Our Ref : 2013/354274
File No : S076158.049
Your Ref : MP07_0158

**Modification Request for Sydney University Abercrombie Precinct
Redevelopment (MP07_0158 MOD 2)**

Louise Kerr
Acting Director City Planning, Development and Transport

Figure 9: Proposed Centralised Rooftop Plant Area

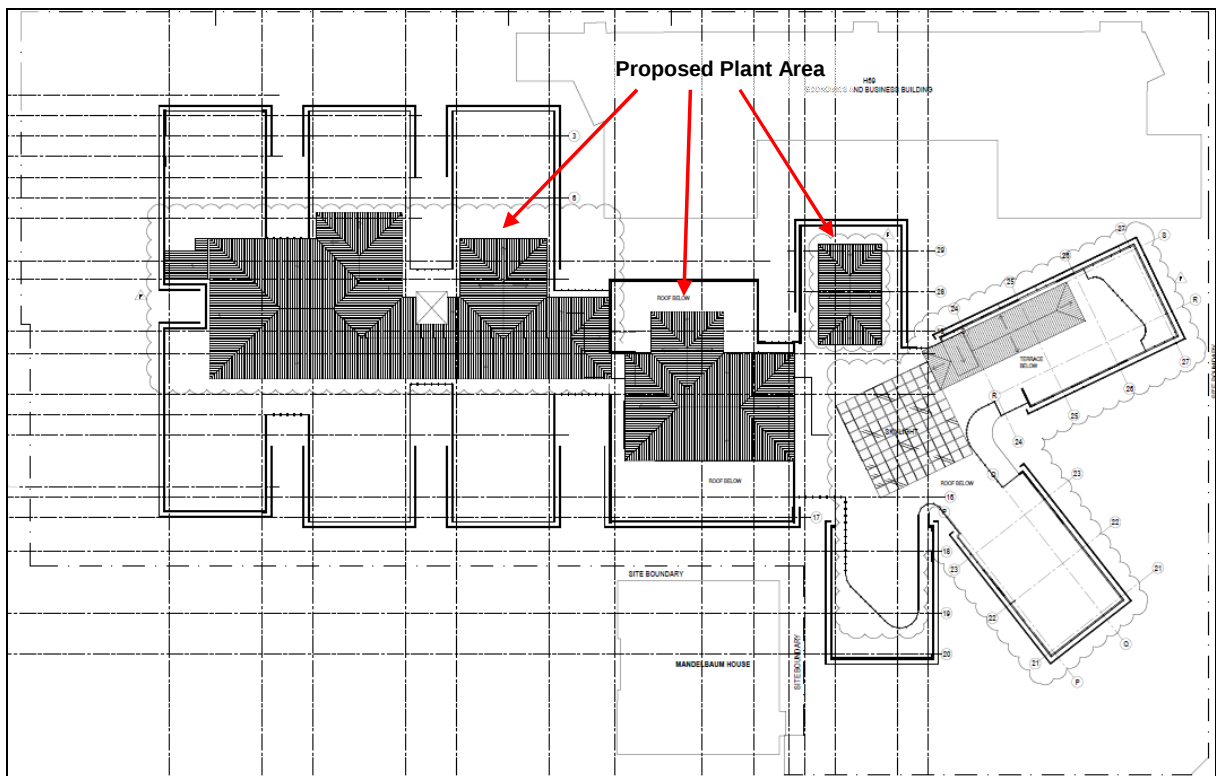
Many of the proposed changes evident in the building elevations relate to the reorganisation and consolidation of the plant and service rooms and the introduction of a new roof structure over much of the western part of the complex. Most evident in the elevations, this consolidation reduces the visual clutter of multiple rectangular forms projecting above the building. The proposed revisions present a cleaner contemporary appearance. However, some concern is raised over the length of the metal plant room louvers used as an external treatment, and the ability to provide some break in these horizontal elements which is not clearly represented.

The proposed removal of the green roof and reduced terrace planting is not a positive outcome. A green roof element could still be adopted with the proposed consolidation of plant rooms and the amended roof design.

Drawing Title
PLAN
GROUND FLOOR

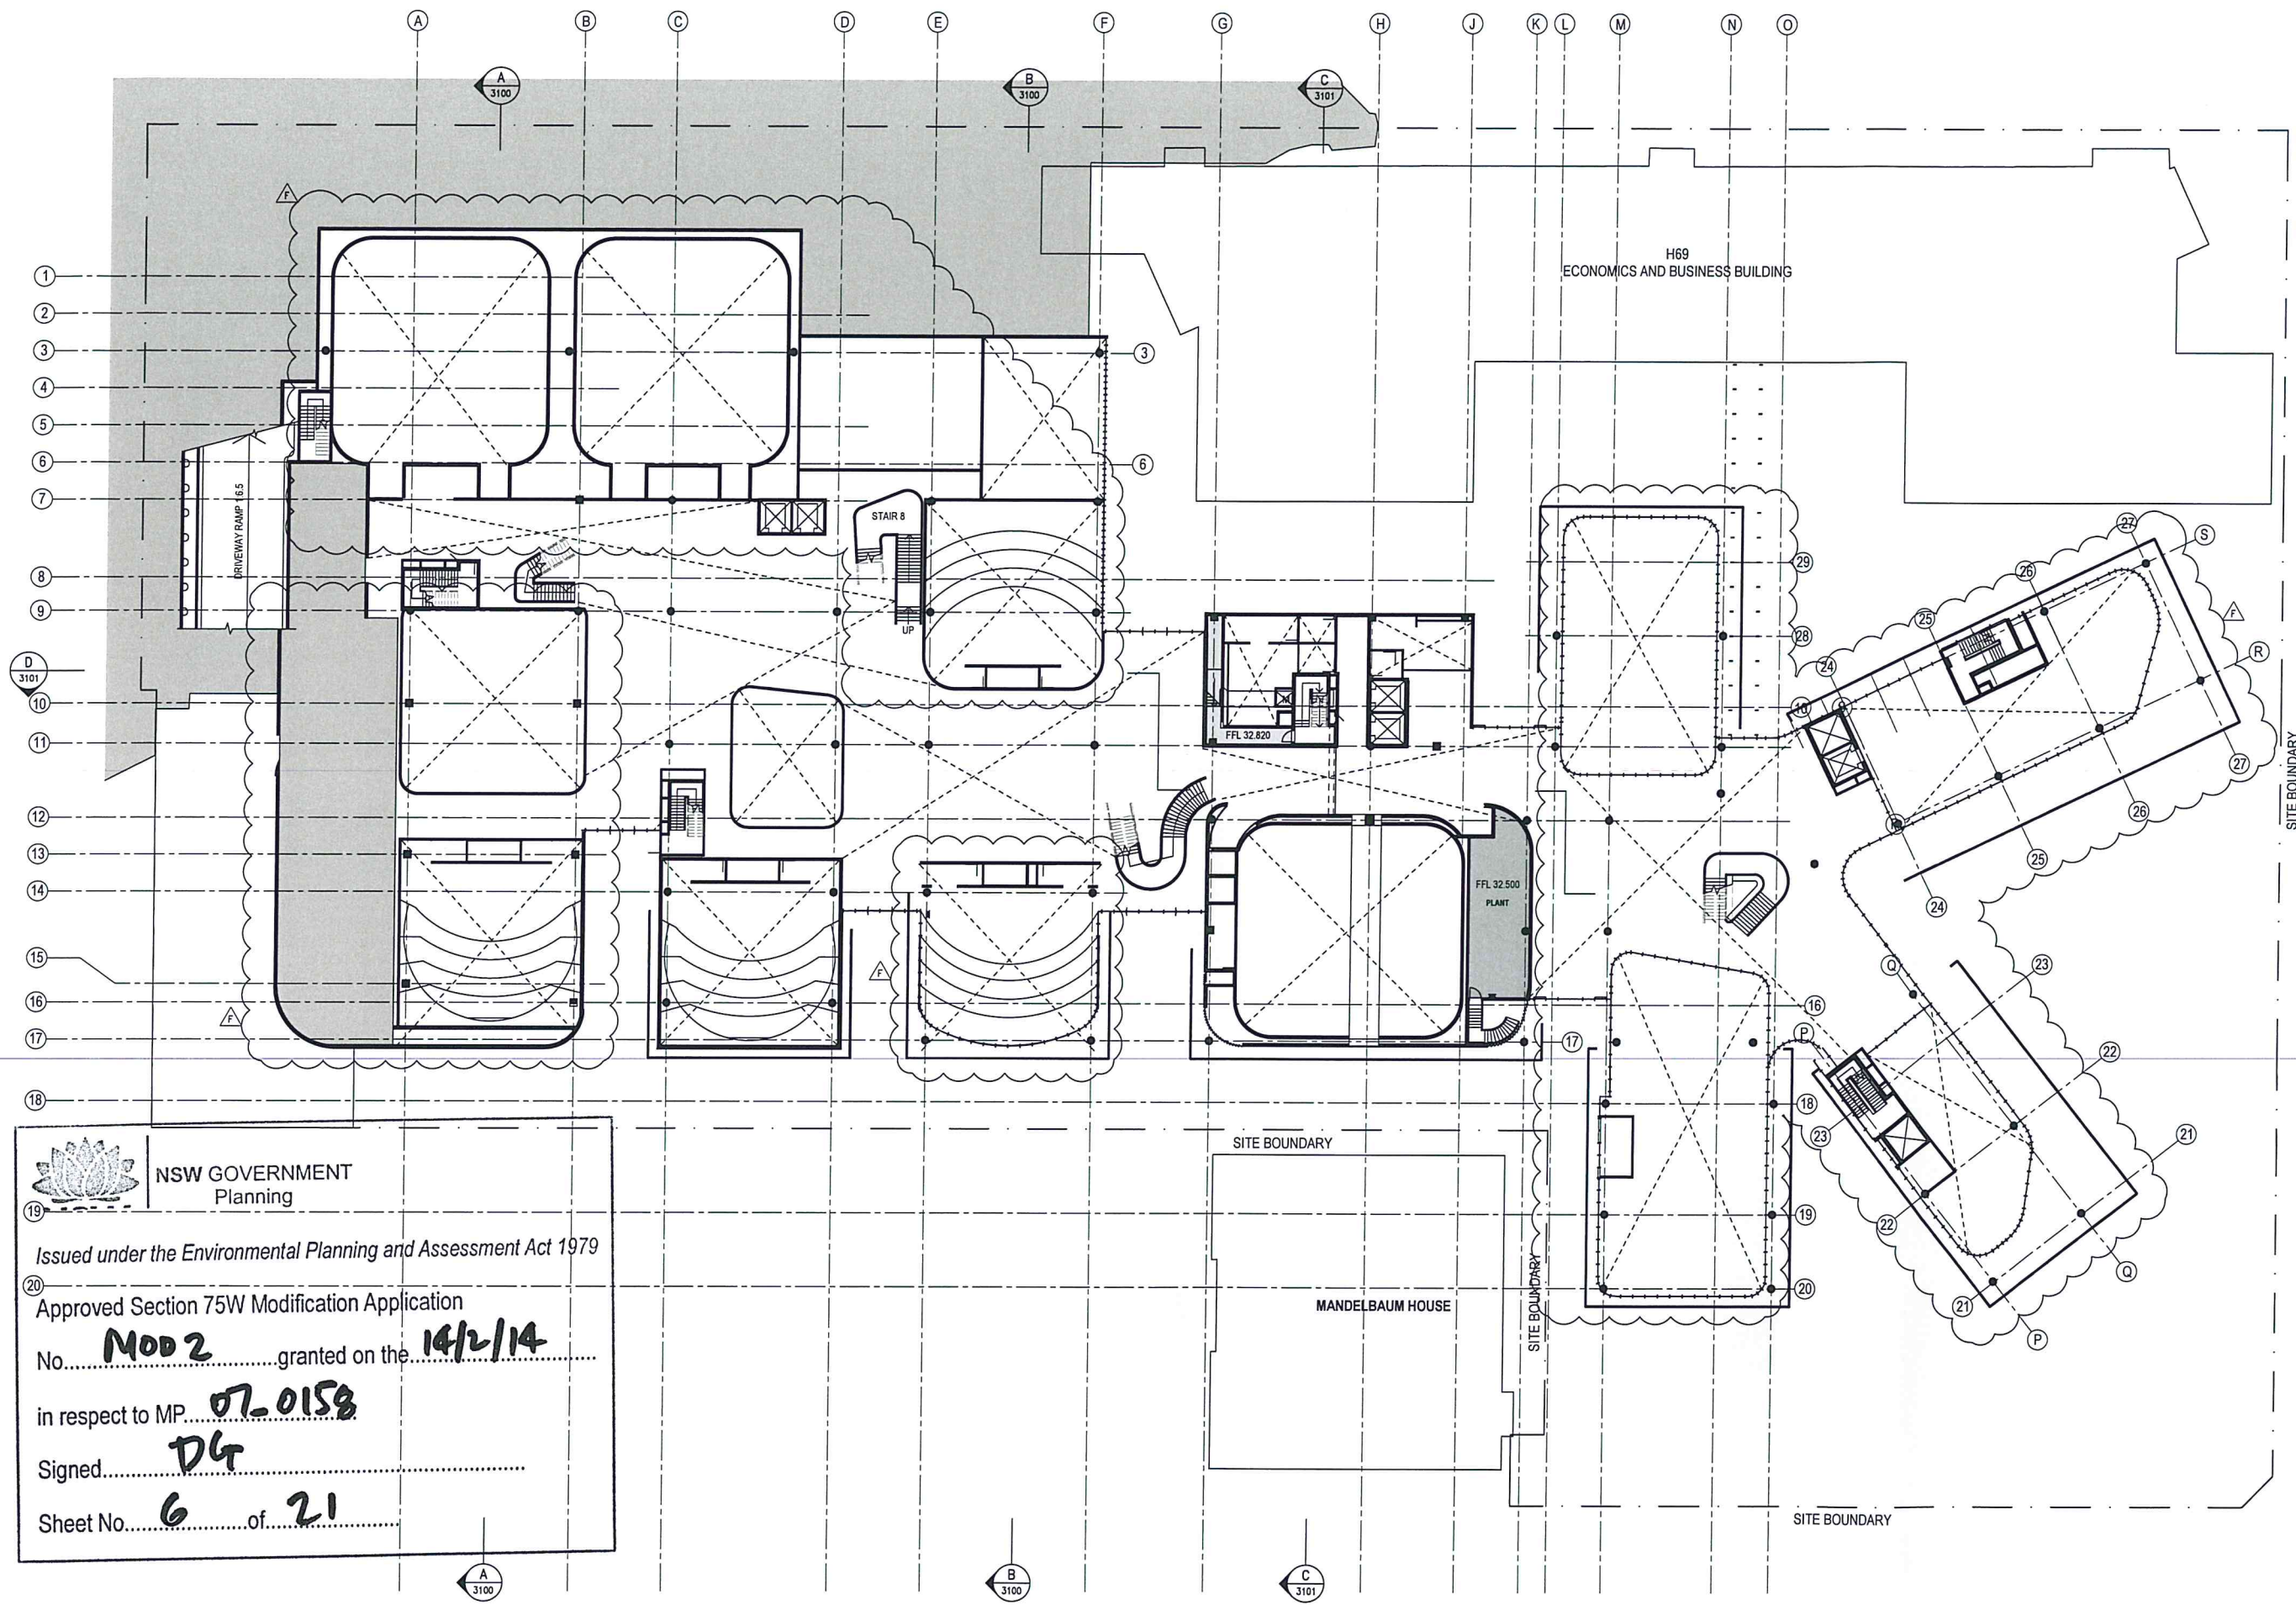
The majority of the building wing directly to the east of Mandelbaum House, has been setback to a slightly greater degree from Abercrombie Street than currently approved. However, the loss of the truncated frontage to the ground floor 'Learning Hub' appears to result in a net loss of open space. The 'squaring off' of the ground floor will remove an architectural feature that ties this element to the design of the wings that project towards Codrington Street and will seek to further enclose the south facing outdoor space immediately to its east. Retention of the truncation to the ground floor provides a better outcome.

From the northern boundary and Darlington Lane, the setback has been increased to both the substation and the three wings of the building in the north-west of the site. The increased setback in general is supported as it increases the potential for landscaping and useable outdoor areas. However, the substation does not appear to be represented in the Darlington Lane elevation. Its elevation from the subterranean level to level 01 will make it a prominent feature from Darlington Lane. The necessity of the loading bay running the length of the building and adjoining Darlington Lane is questioned and some provision could be made for some soft landscaping in and around this area.

The modified proposal presents a reduction in the number of trees and soft landscaping across the site, which is not supported. The modified landscaping scheme removes any planting immediately adjoining building elements, which would otherwise aid in softening the built form and also assist in solar absorption.

The Interim Traffic Statement by TTW states that any proposed driveway to the site on Darlington Lane requires the lane to be one way. Council's Transport Planning unit is generally supportive of both the one way arrangement and the proposed driveway from this lane. However, the conversion of the lane from two-way to one way is not something that can be approved as part of this application, and as such the application in its current form cannot be supported without the appropriate approvals in place.

A solution provided by Council's Transport Planning unit is to require the applicant to provide a passing bay within their land such that if in the absence of approval for a one way conversion, the lane could still cope with the additional level of traffic. It is noted that the substation next to the driveway has a space in front of it large enough for a passing bay. This could be designed to operate as a passing bay and then if/when the requisite approvals are obtained for Darlington Lane to become one way the passing bay requirement can be rescinded.

The design for the Darlington Lane frontage must be amended to include the provision of a passing bay.

RENDERED ELEVATION - NORTH (DARLINGTON LANE)

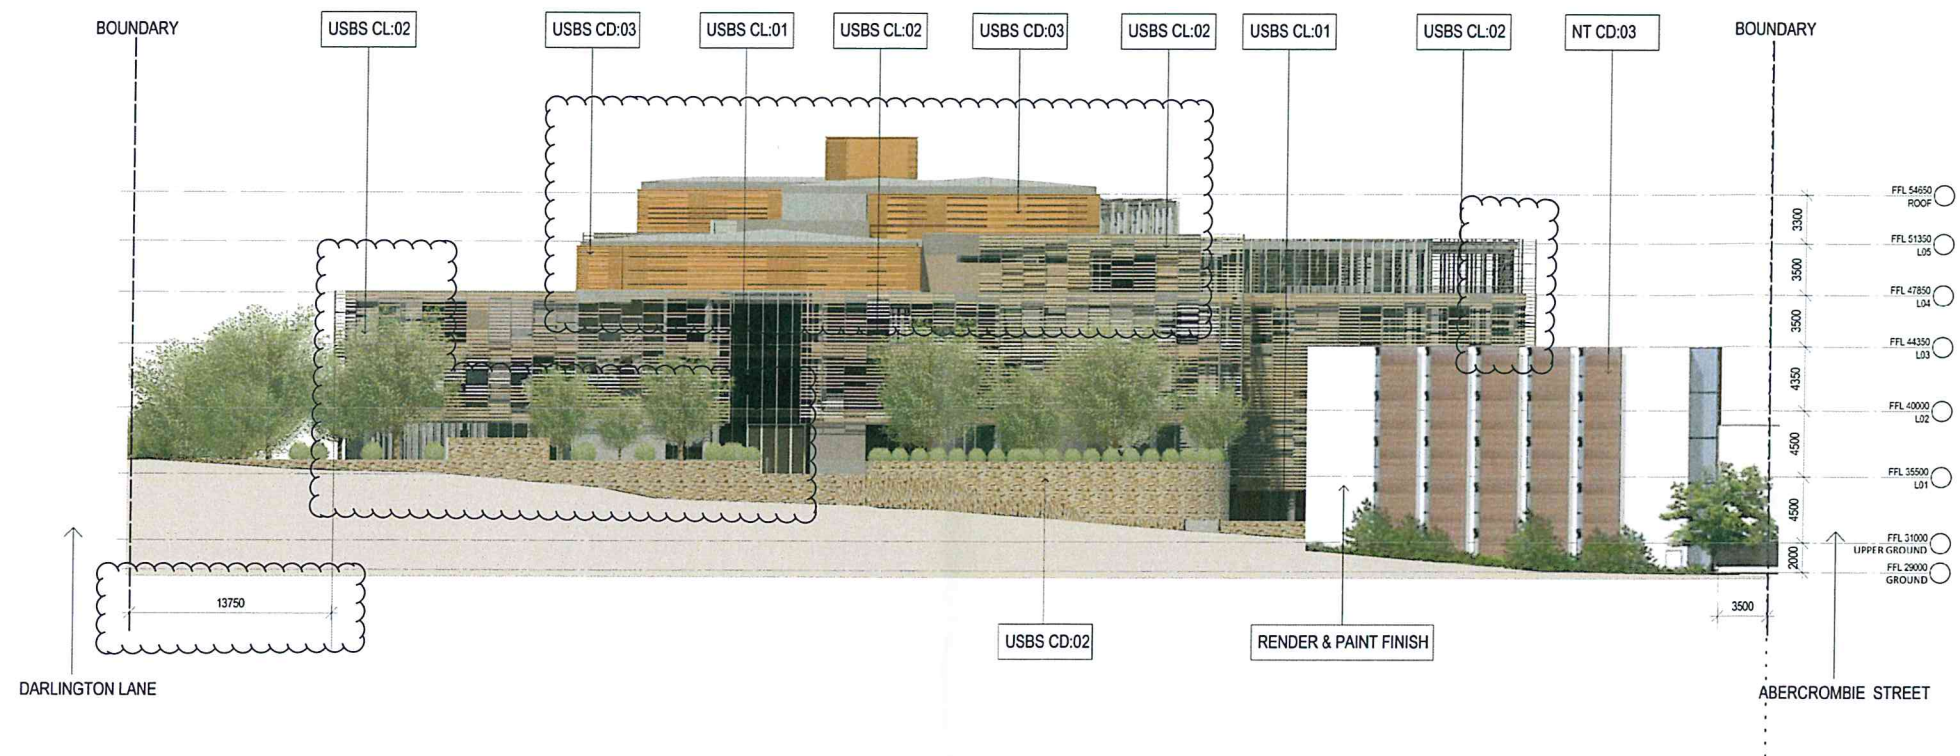
Two 300 seat theatres currently approved on the lower ground level are to be relocated towards the north-west portion of the site. This location presents a larger continuous building element towards Darlington Lane, however, this is offset by an
